14 December 2015

File Number: 2015/658785  
Our Ref: R/2015/26/A

**RE: State Significant Development 7133 – Building W1 Student  
Accommodation, Darling Drive Plot, Sydney International Convention,  
Exhibition and Entertainment Precinct**

PERSPECTIVE 2 - LOOKING WEST INTO THE COURTYARD

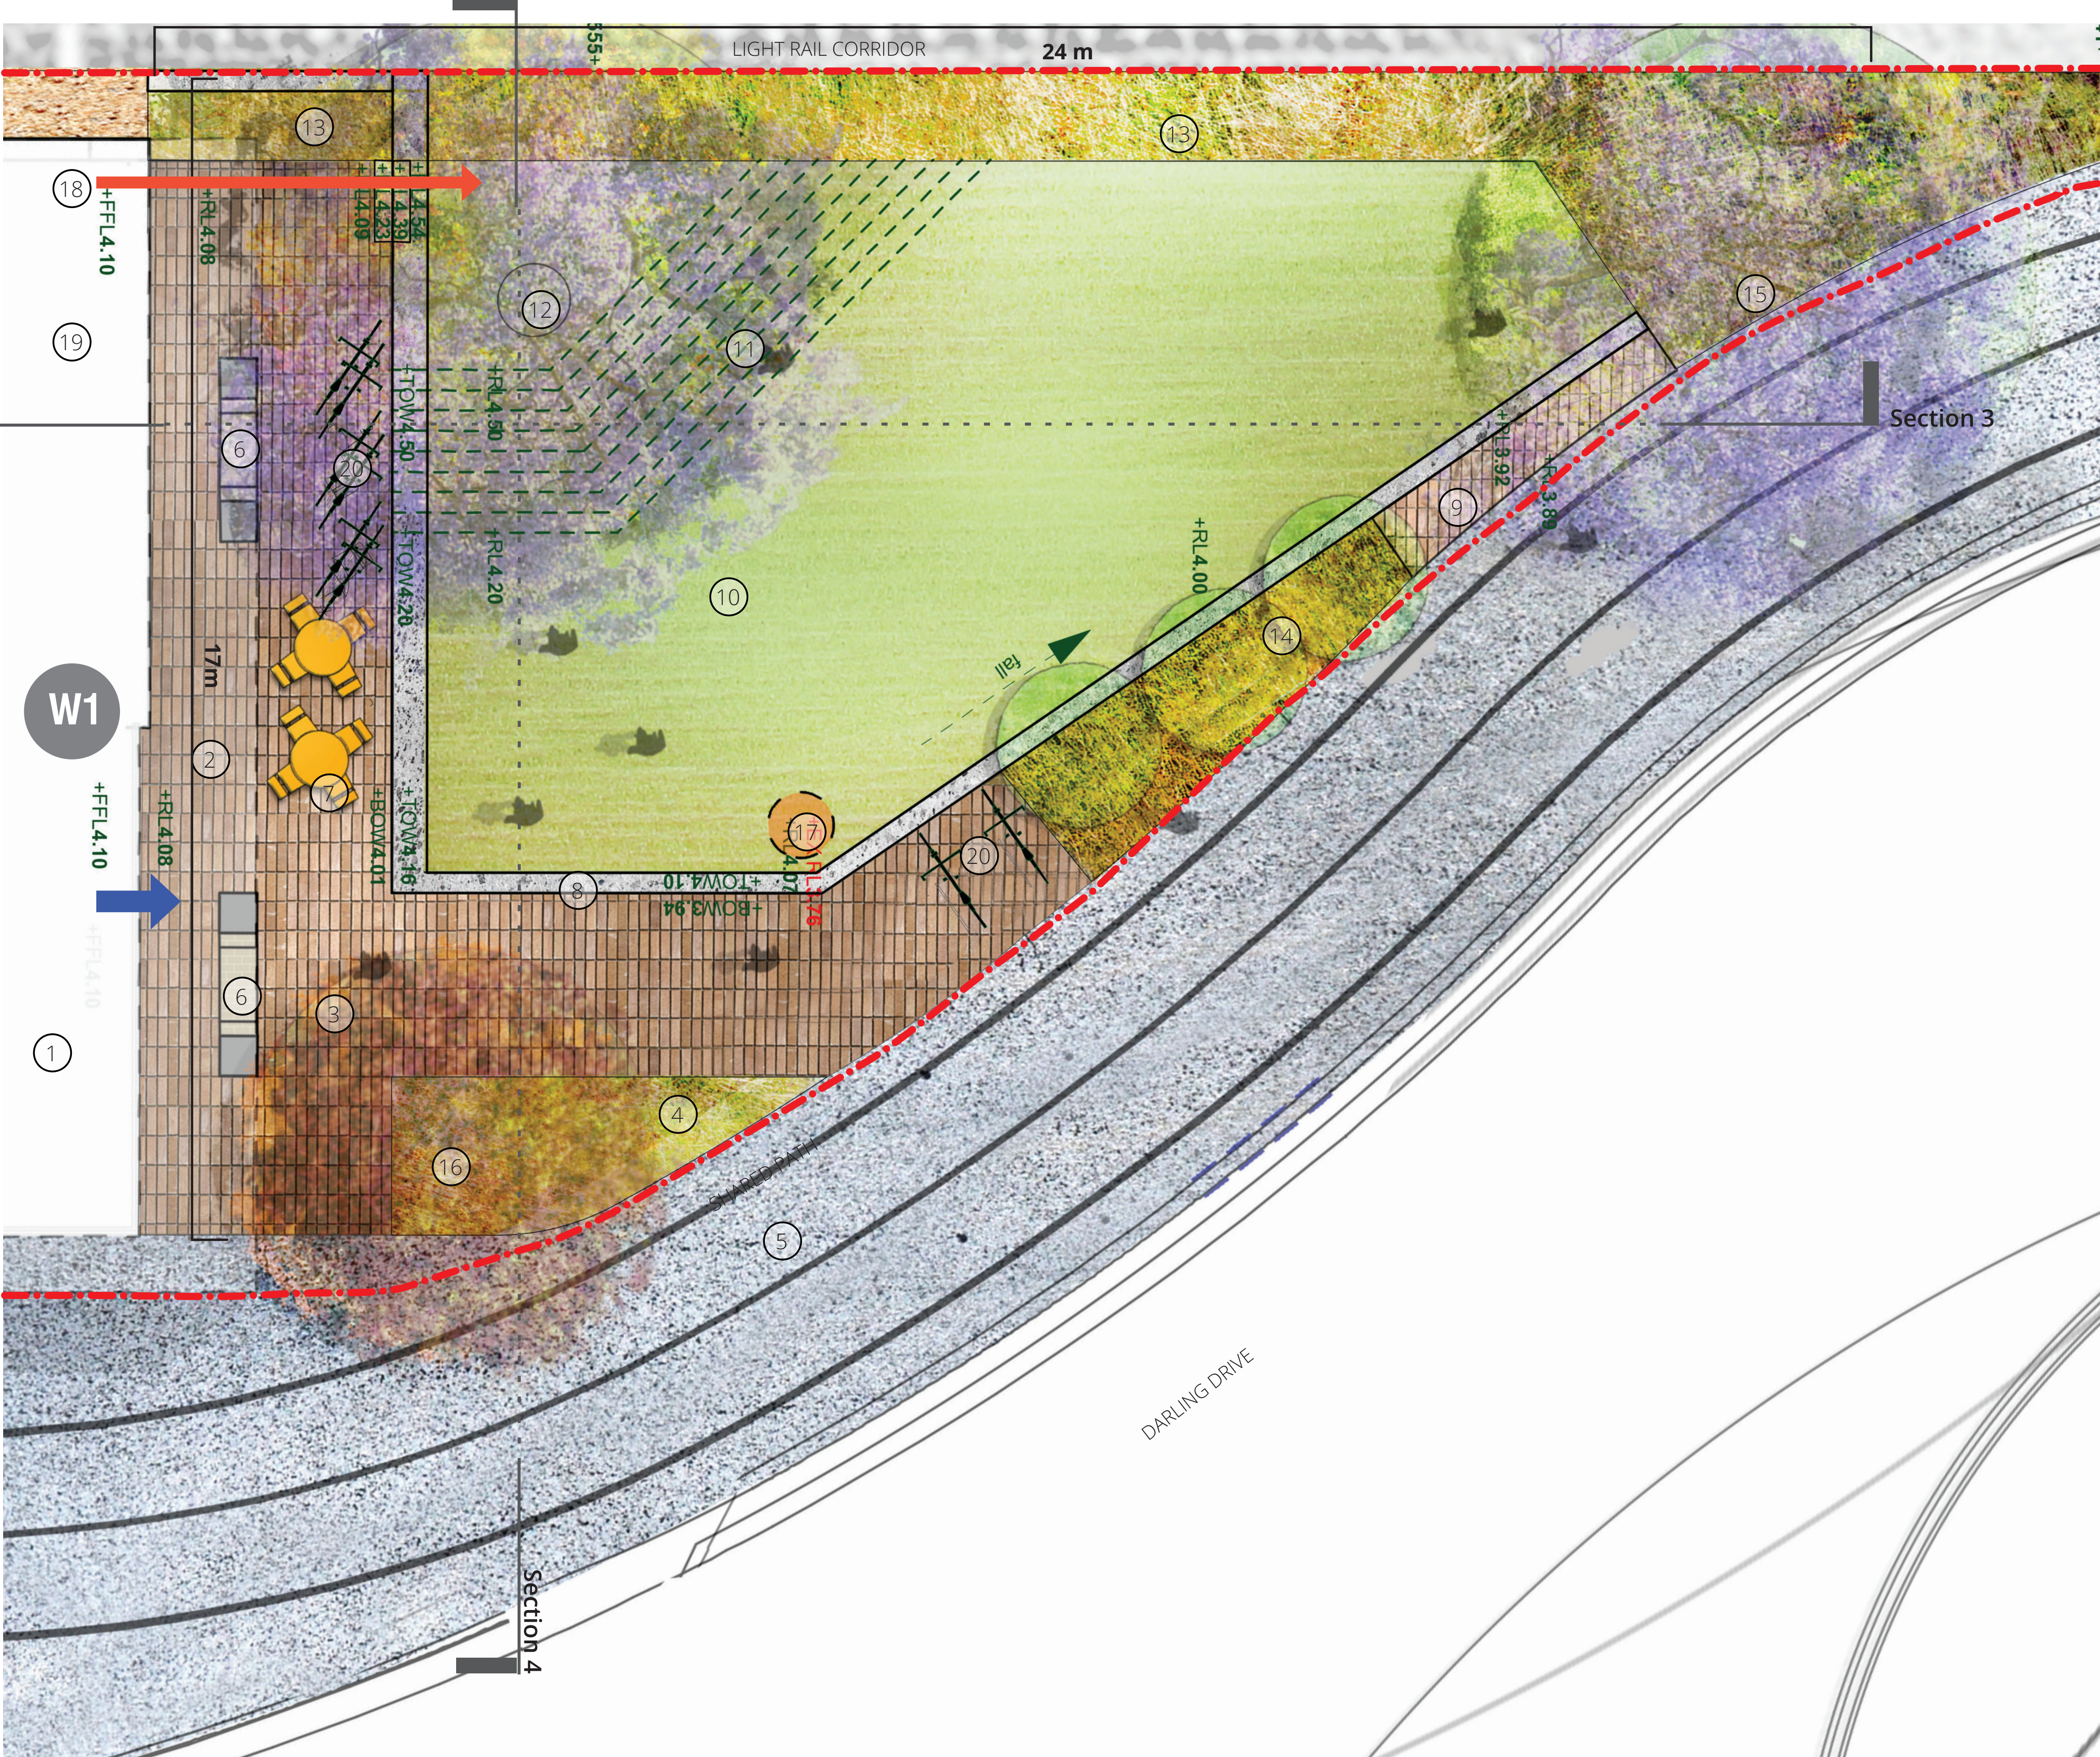
**Privacy:** The central courtyard appears to be designed solely for student use, however is publically accessible. Given the limited activation and overlooking, and the sometimes awkward interface between doors and columns, this space could be better utilised if secured and made private.

**Activation:** The majority of frontage to the central courtyard is services, including garbage and substation. The entrance to building W1, and a possible exit from W2 is the only activation of the space. If the courtyard is secured as recommended above, the applicant should ensure clear and visible access to the space from both buildings.

**Interface between doors & columns:** All doors leading to the ground level outdoor spaces appear to be positioned behind columns, further limiting the activation of the spaces, and possibly blocking direct views to the building entries. The applicant should ensure all building entries are clearly visible, and not blocked by columns.

**Boundary to light rail:** The boundary between the central courtyard and light rail should be designed as an element that integrates with the built form, unifying the space. The applicant should consider designing an integrated element connecting the two buildings and forming the boundary to the light rail, removing the need for the chainlink fence.

Drawing Title
NORTH & EAST ELEVATIONS

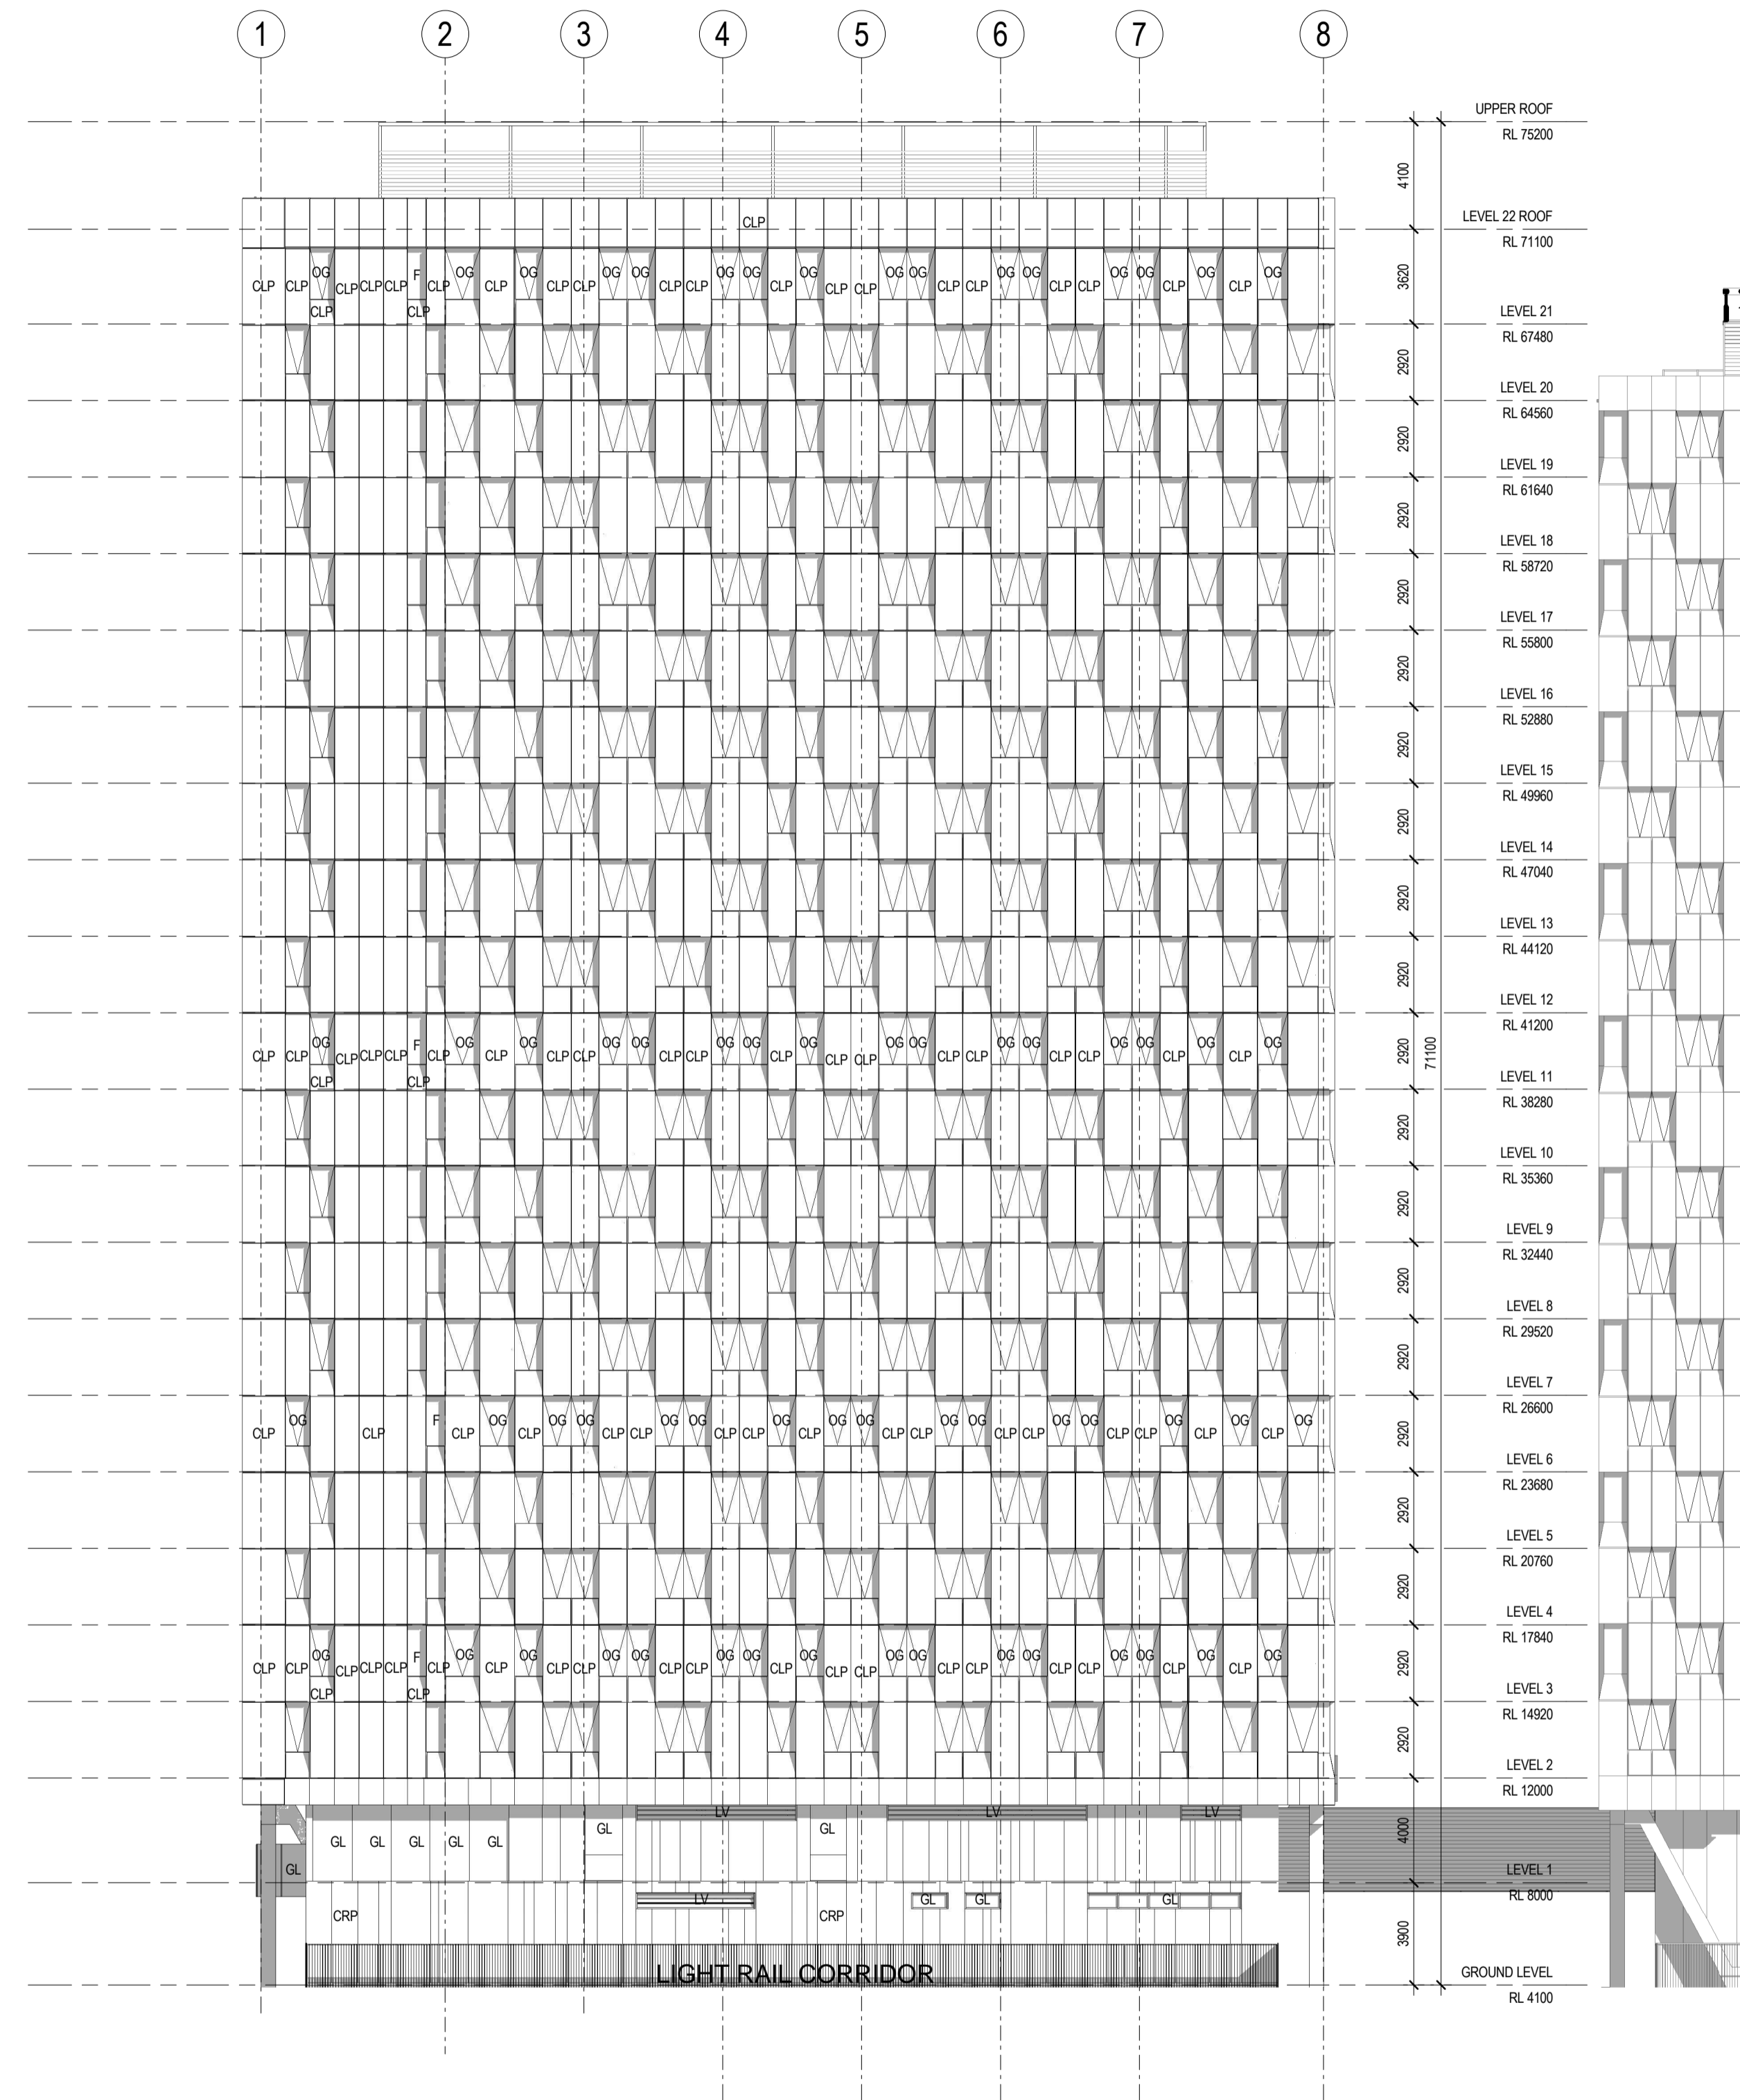
**V columns:** The street wall façade concept of the 'V' columns at the lowest two levels is supported as an architectural concept, particularly as it extends from approved Building W2 to provide a consistent façade treatment along Darling Drive, reflecting the consistency of building use between the two buildings. However, along the north eastern corner of W1 an external balcony has been introduced at level 1 which effectively cuts the 'V' columns in half and reduces the strength of the concept. The City would support a smaller deck which does not extend past the internal line of the 'V' columns.

It is also noted that insufficient information is provided on the proposed construction of the 'V' columns to assess the robustness of the material. The consent authority should ensure that the cladding for the 'V' columns is robust, durable and capable of withstanding impacts from its prominent position within the public domain. Materials are to be self-finished.

1 WEST ELEVATION 1:200

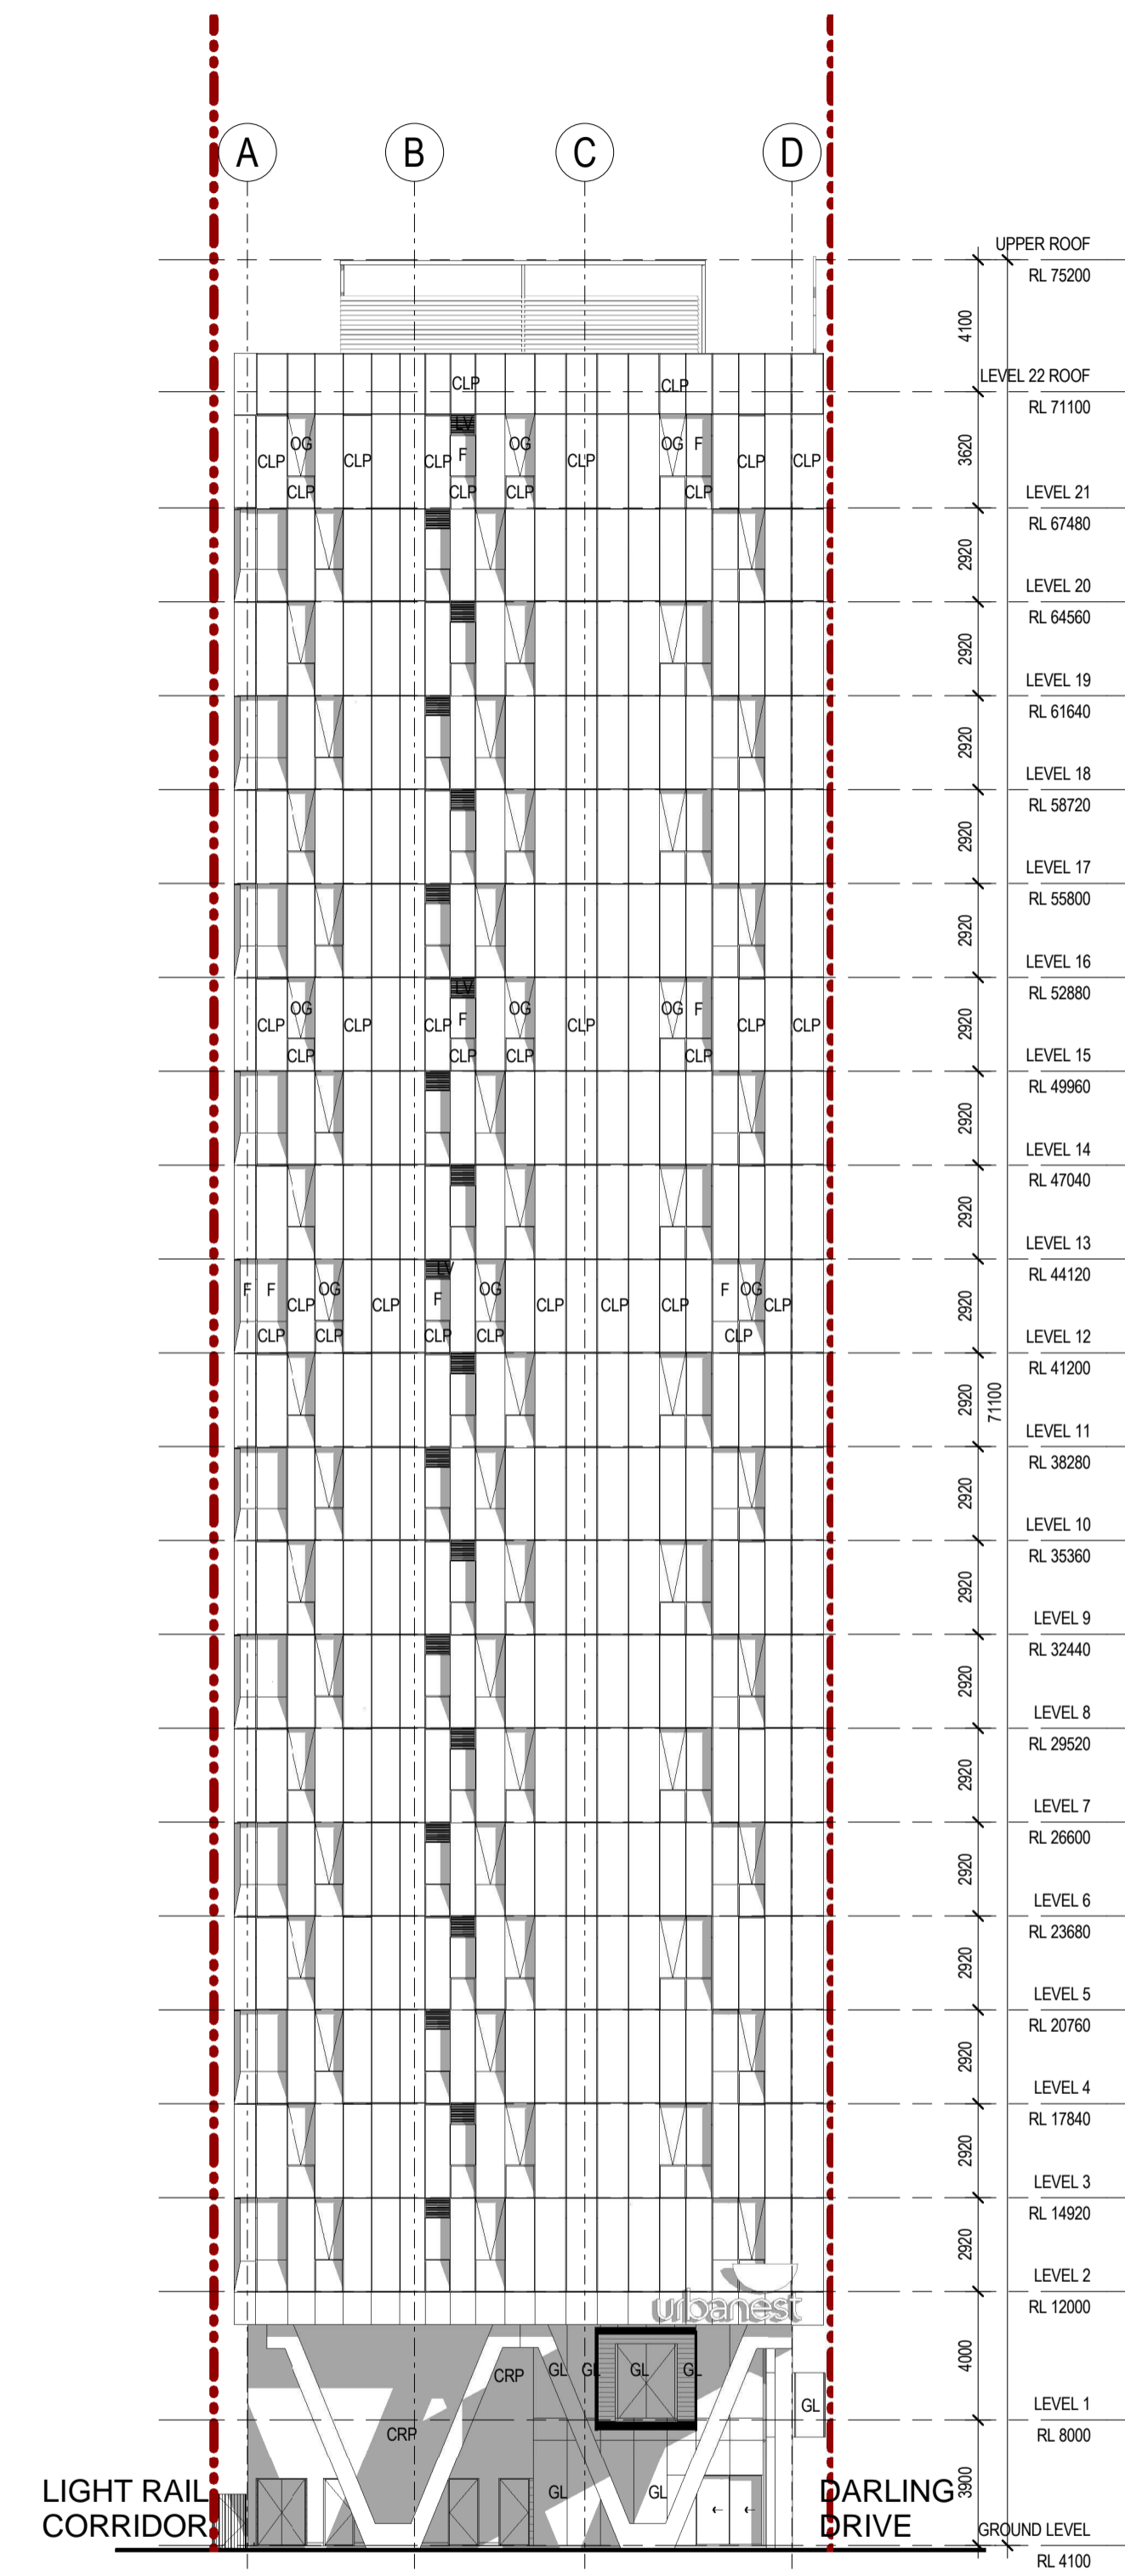
**Western façade:** It is unclear from the proposal how the facade which fronts the heavy rail corridor is proposed to be accessed for cleaning and maintenance. Further clarity is required to confirm that the use of the building maintenance unit on the south elevation will not impact on the operation of the heavy rail corridor.
